Development Control
Ribbles Valley Borough Council

App no: 22.0568

Address: Land to rear of Malt Kiln House Malt Kiln Brow Chipping

Proposal: Four new, two-storey residential dwellings

DRAWING TITLE
Drainage Strategy.

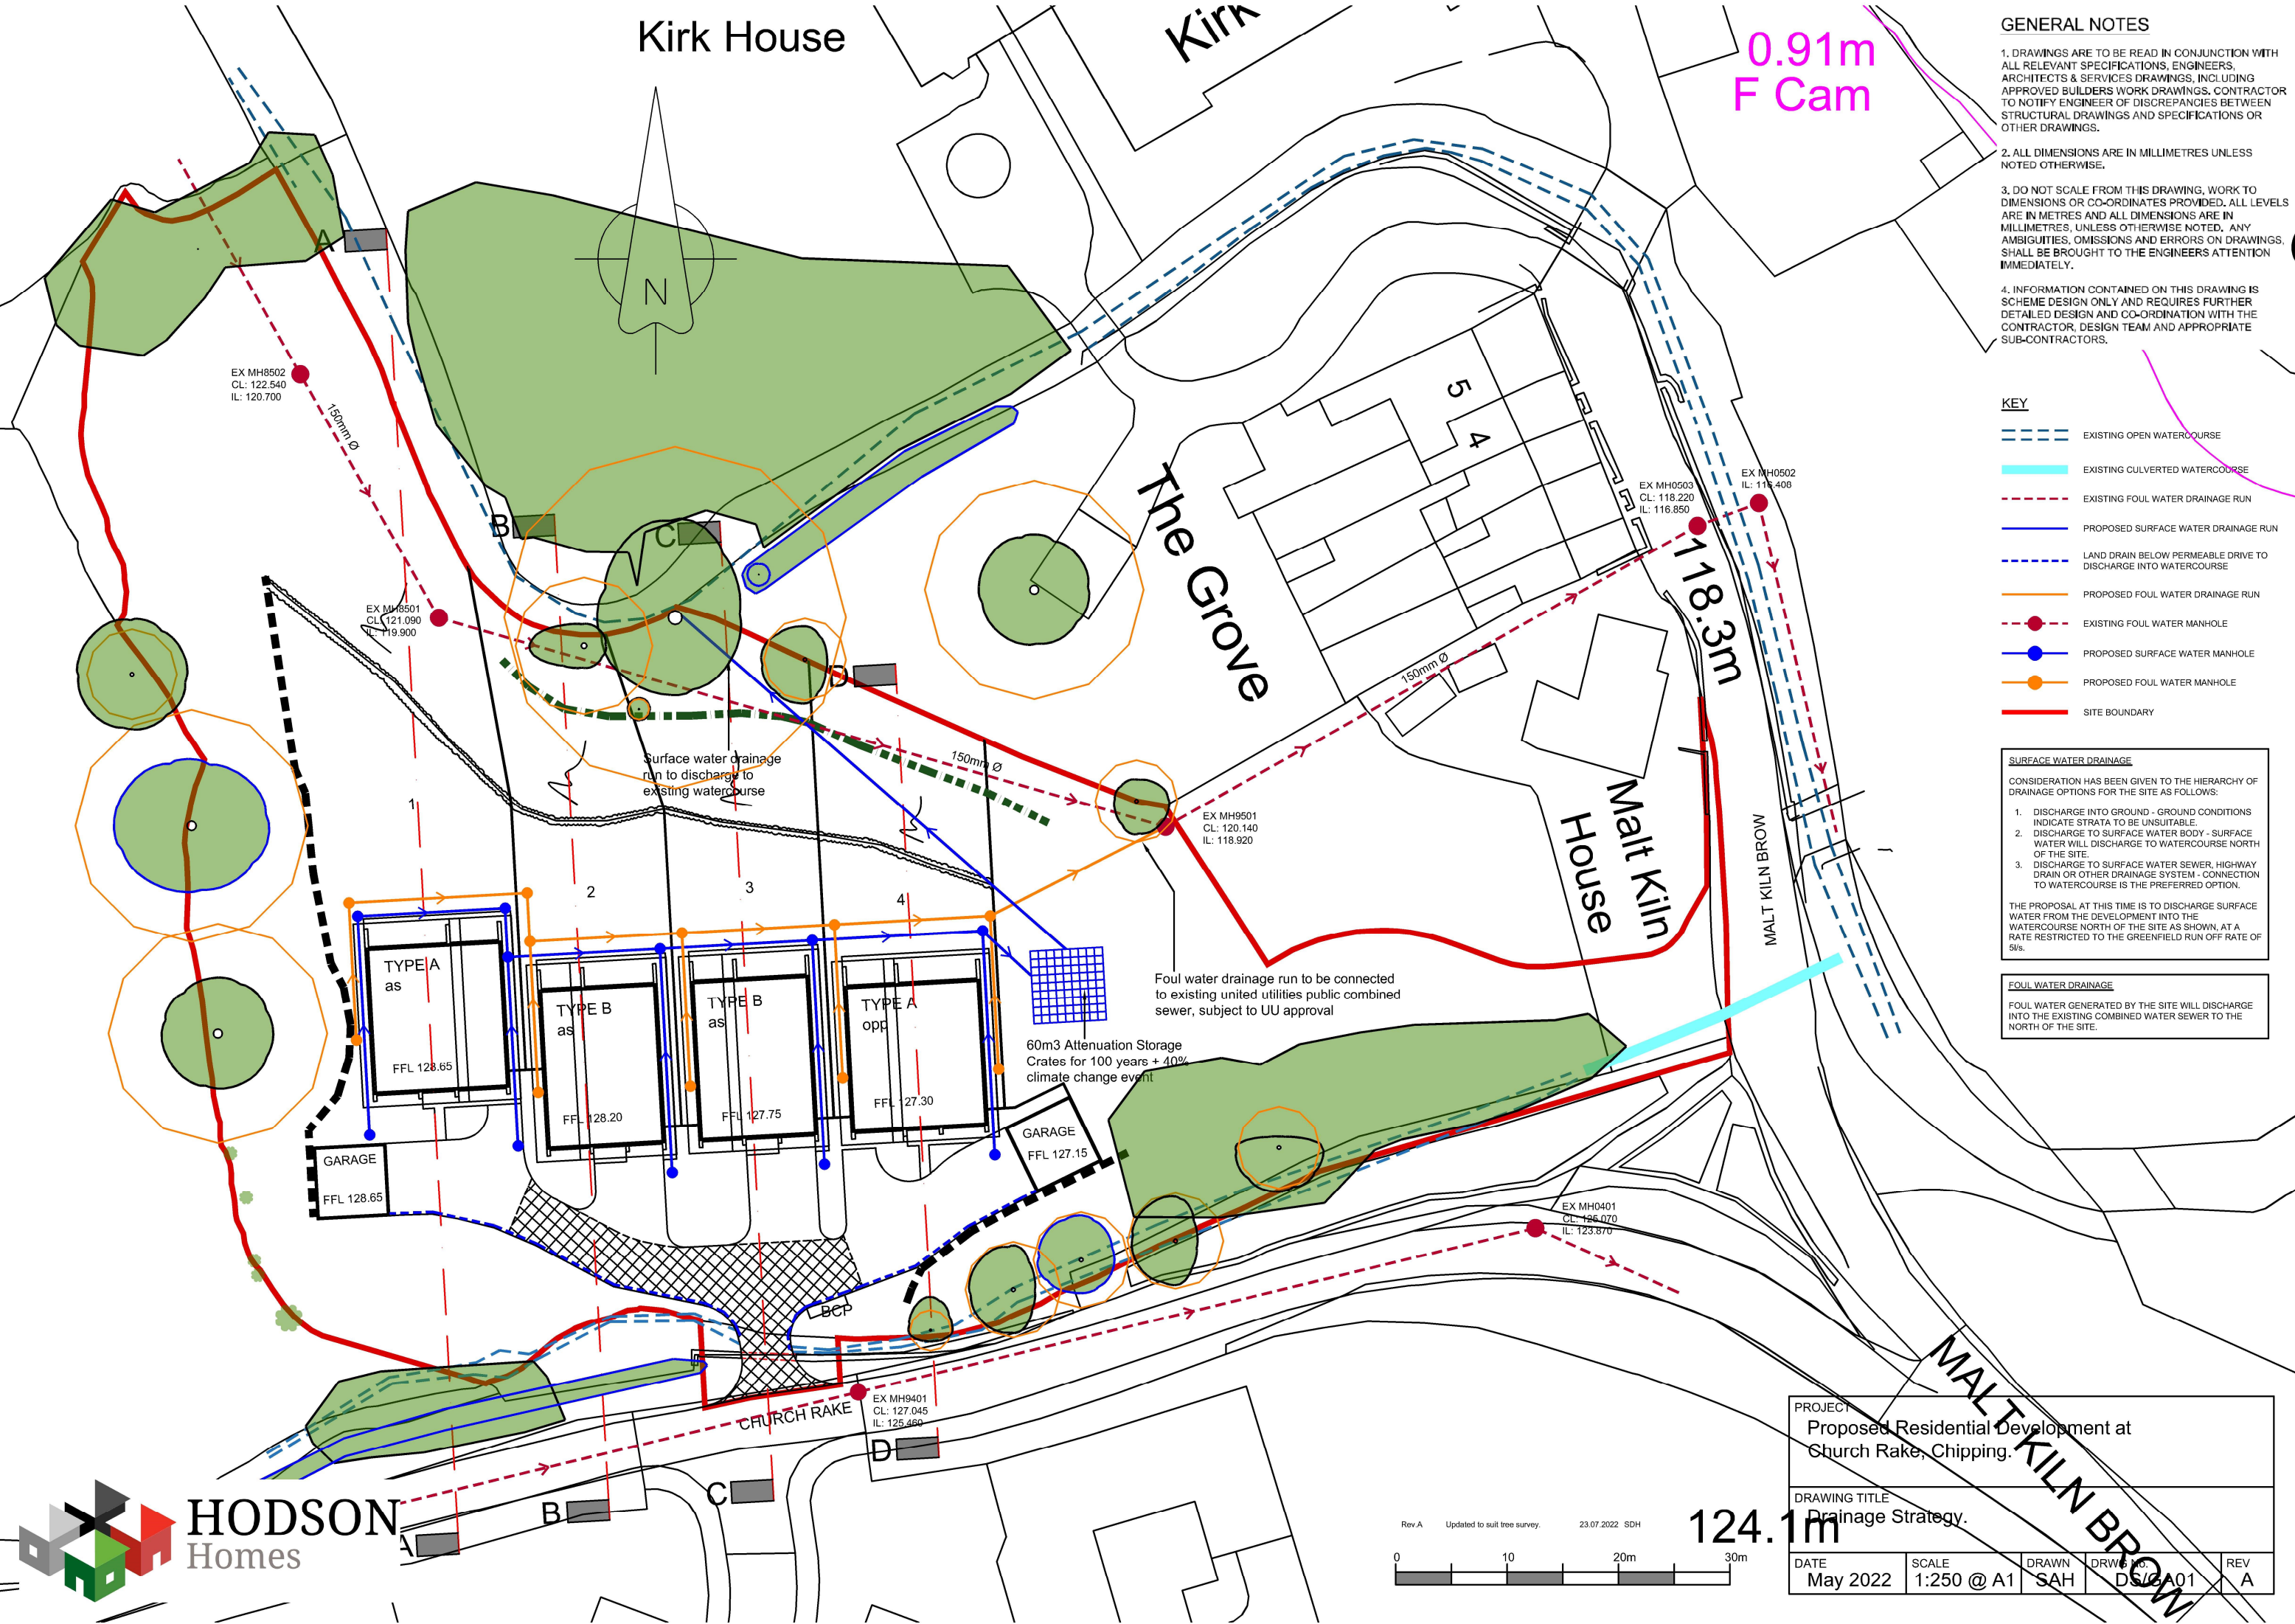
The amended plans have been reviewed, including Hodson Homes 'Proposed site plan' MKB/P01 Rev C, 'Proposed site sections' x 2 drawings MKB/P02 Rev B, 'Drainage strategy Rev A and 'Traffic Management Plan' MKB/P03 Rev B. Newly submitted plans include Hodson Homes 'S278 Highway works – General arrangement MKB/P07 and 'Swept path analysis MKB/P06.

The proposed new access on Fish House Lane requires additional information to determine its suitability including visibility splays and approval in principle to culvert the watercourse from the Lancashire County Council Flood Risk Team.

There is an outstanding matter of the culverting of the watercourse and the developer should note that any planning permission does not entitle the culverting of a watercourse or any ground works adjacent to the watercourse without consent from LCC Flood Risk Team. The developer must make direct contact with the team as they will not review or comment as part of the planning process due to the development being below 10 dwellings.

PROJECT				
Proposed Residential Development at Malt Kiln Brow, Chipping.				
DRAWING TITLE				
Traffic Management Plan.				
DATE	SCALE	DRAWN	DRWG No.	REV
June 2022	1:500 @ A3	SDH	MKB/P03	C

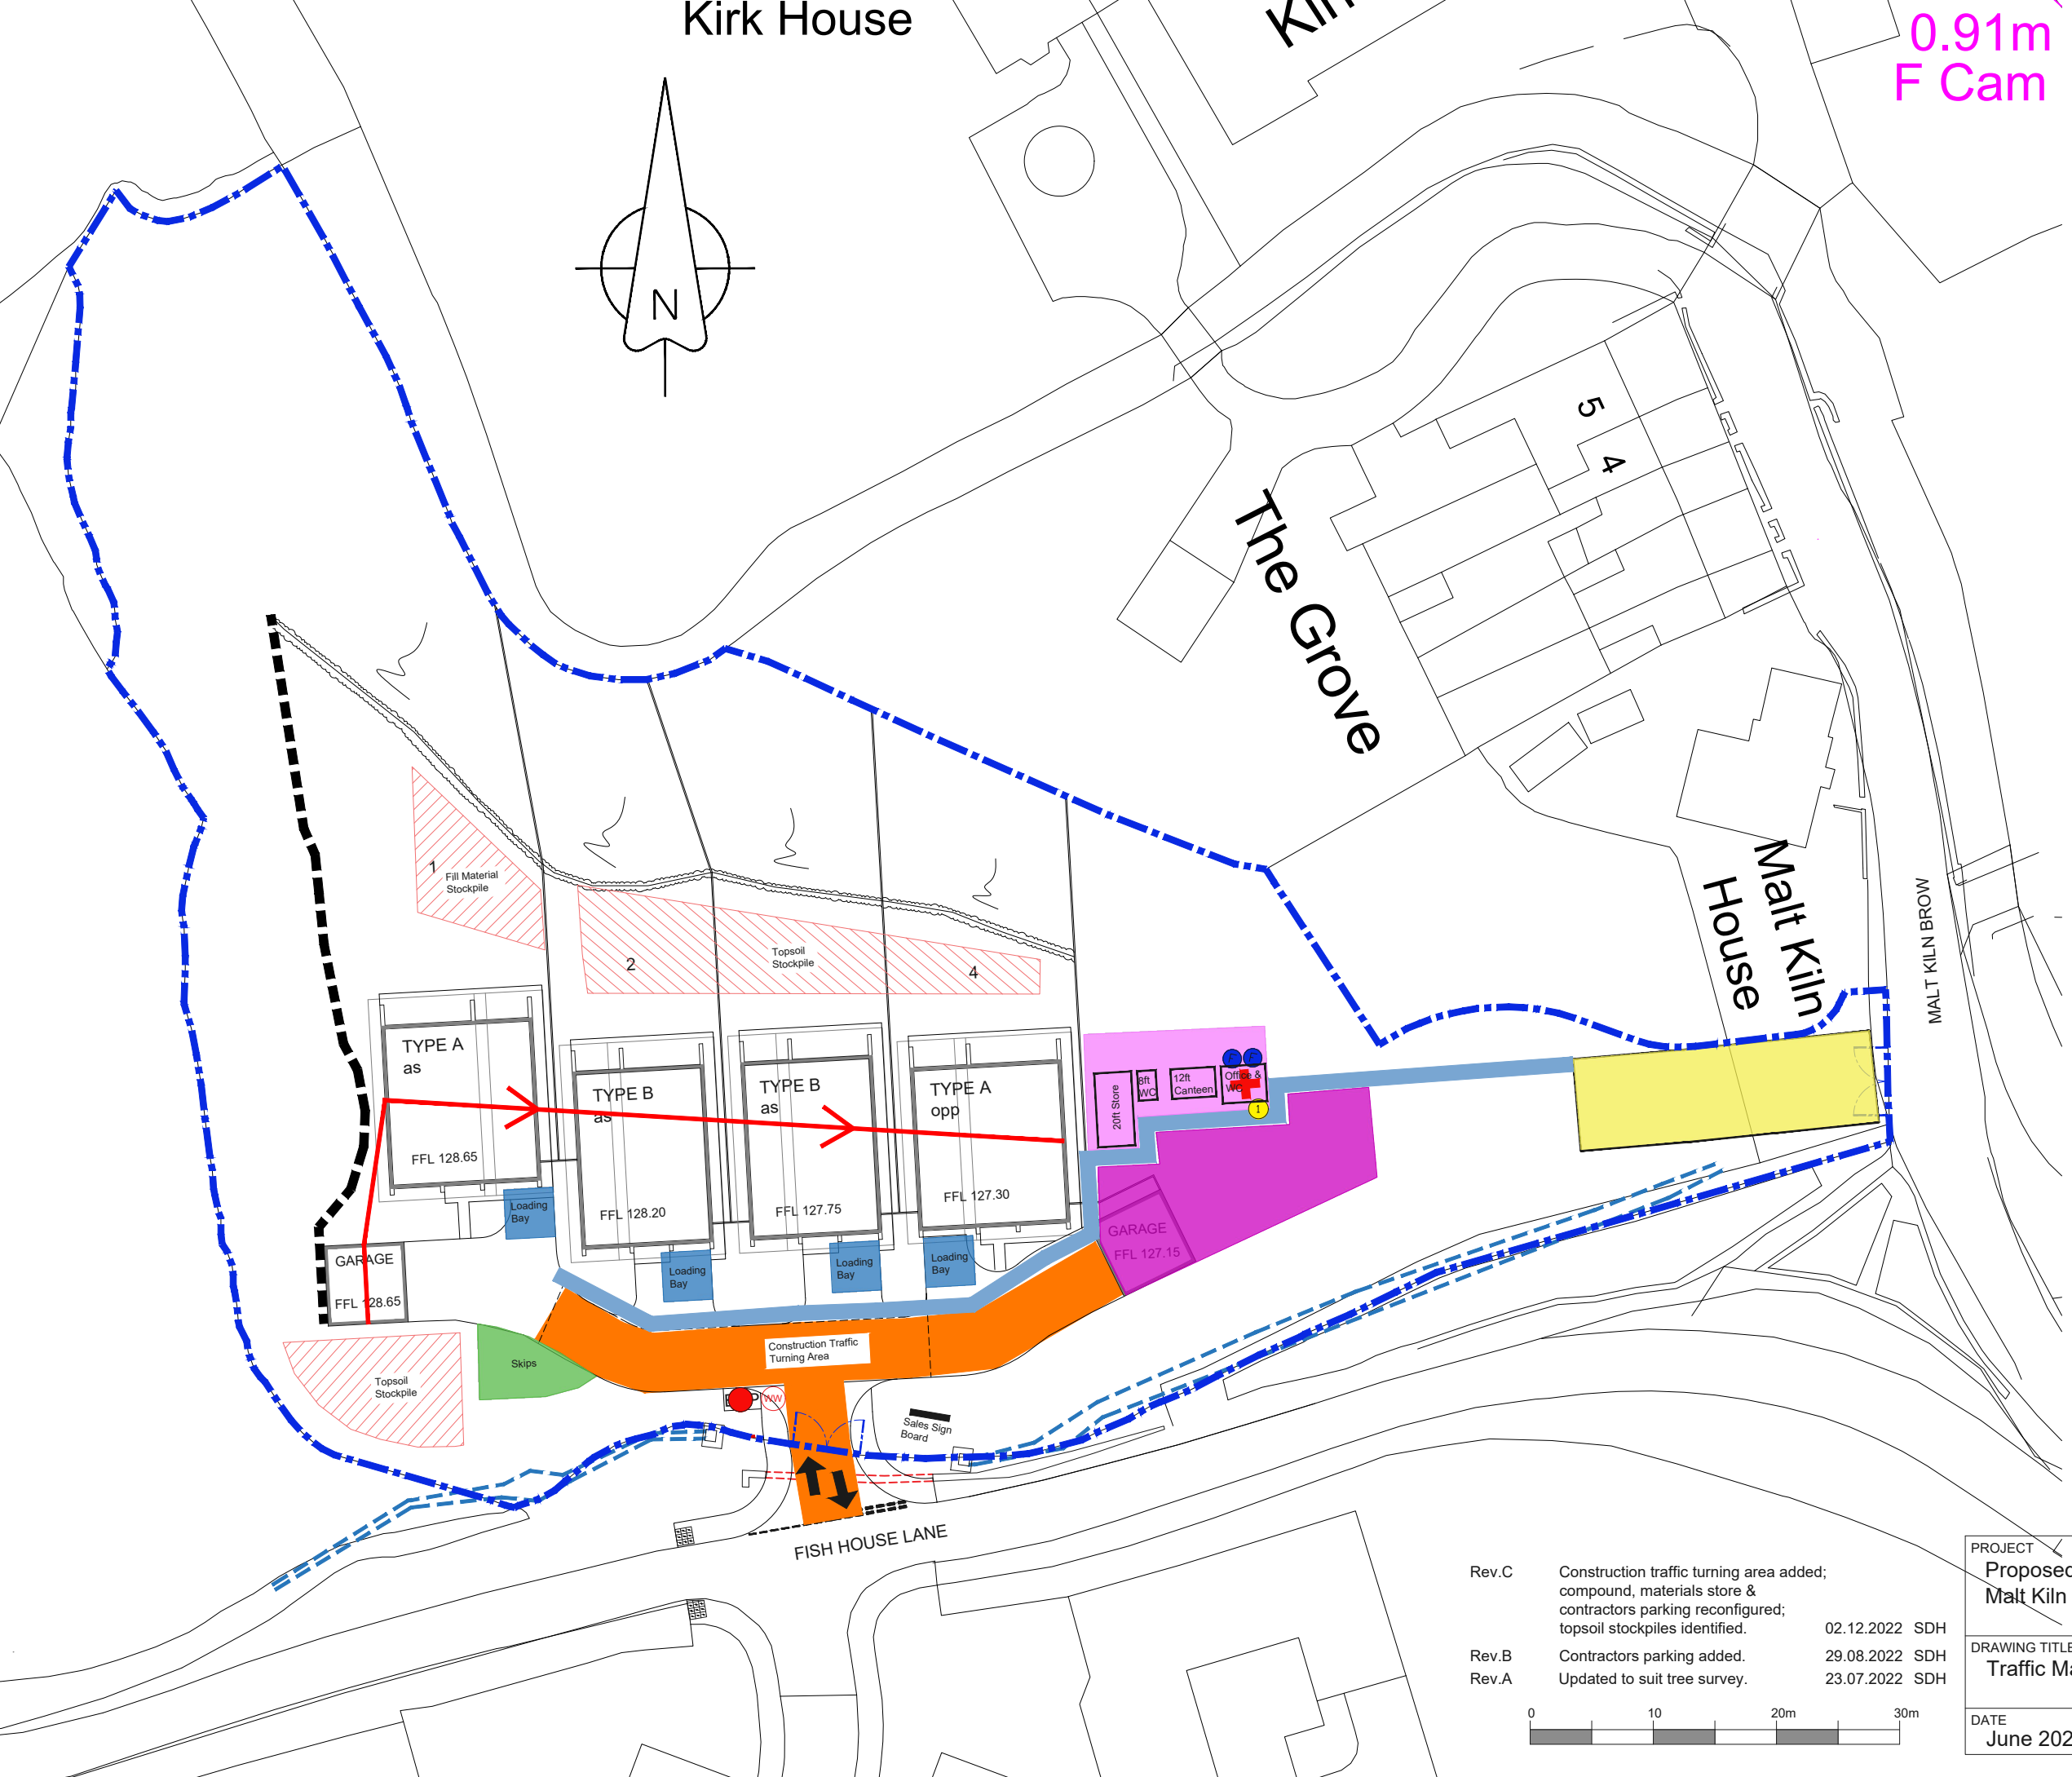
A drawing is submitted titled 'Traffic Management Plan' which shows a compound, storage area and wheel wash on site. Access for construction vehicles is shown entering from Malt Kiln Brow (previously approved access), and exiting onto Fish House Lane, opposite Mills Way via a new access. The amended drawing includes a contractor car parking area as requested and this drawing is now acceptable.

1. The Construction Traffic Management drawing MKB/P03 Rev B shall be adhered to throughout the construction phase.
2. Upon completion of the construction phase, the vehicle access and haul road from Malt Kiln Brow shall be removed and reinstated to its former condition.

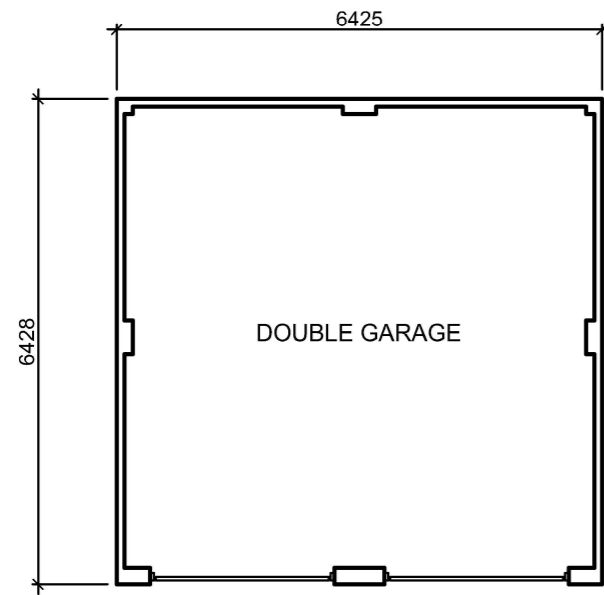
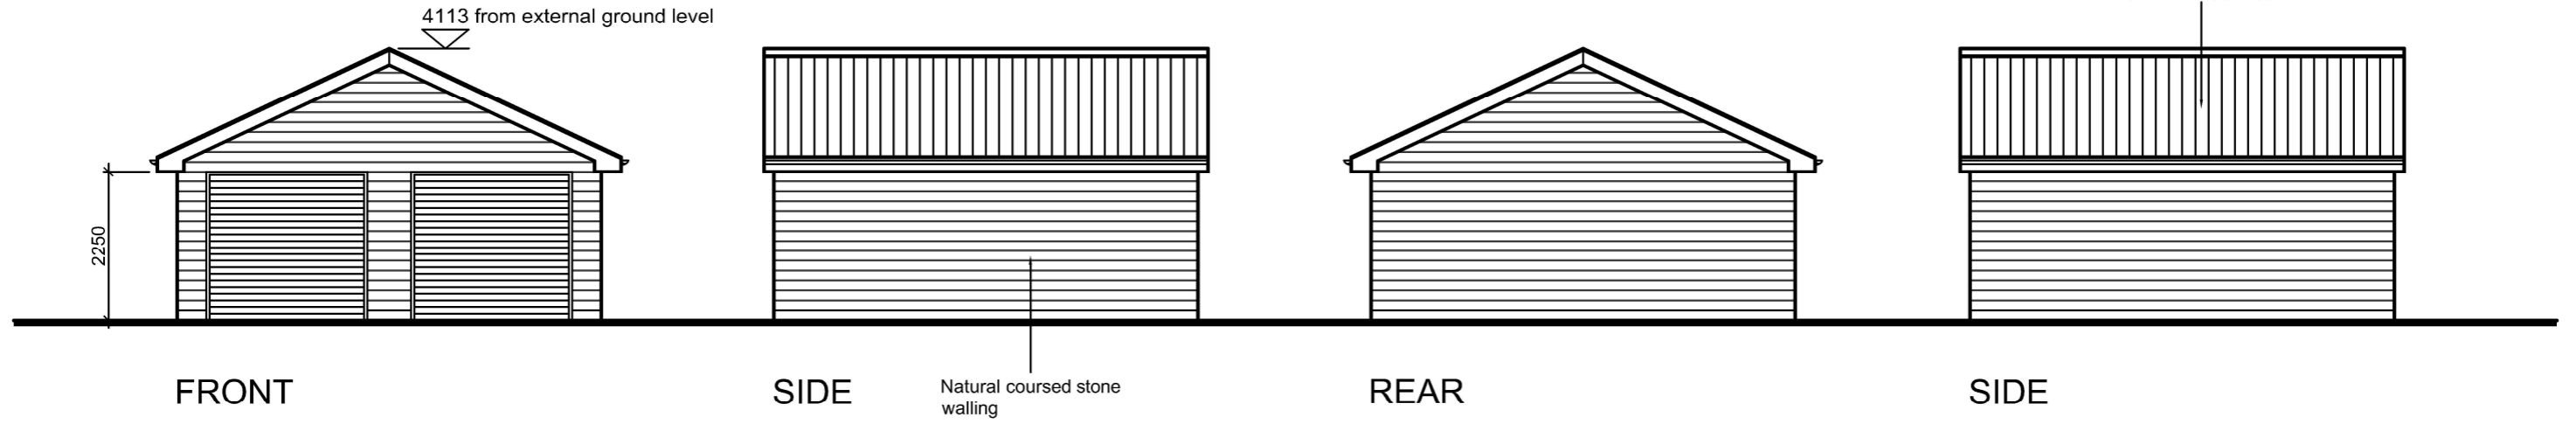
Plots 1 and 4 have detached double garages, measuring internally 6.428m square which is suitable for 2 vehicles and cycles.
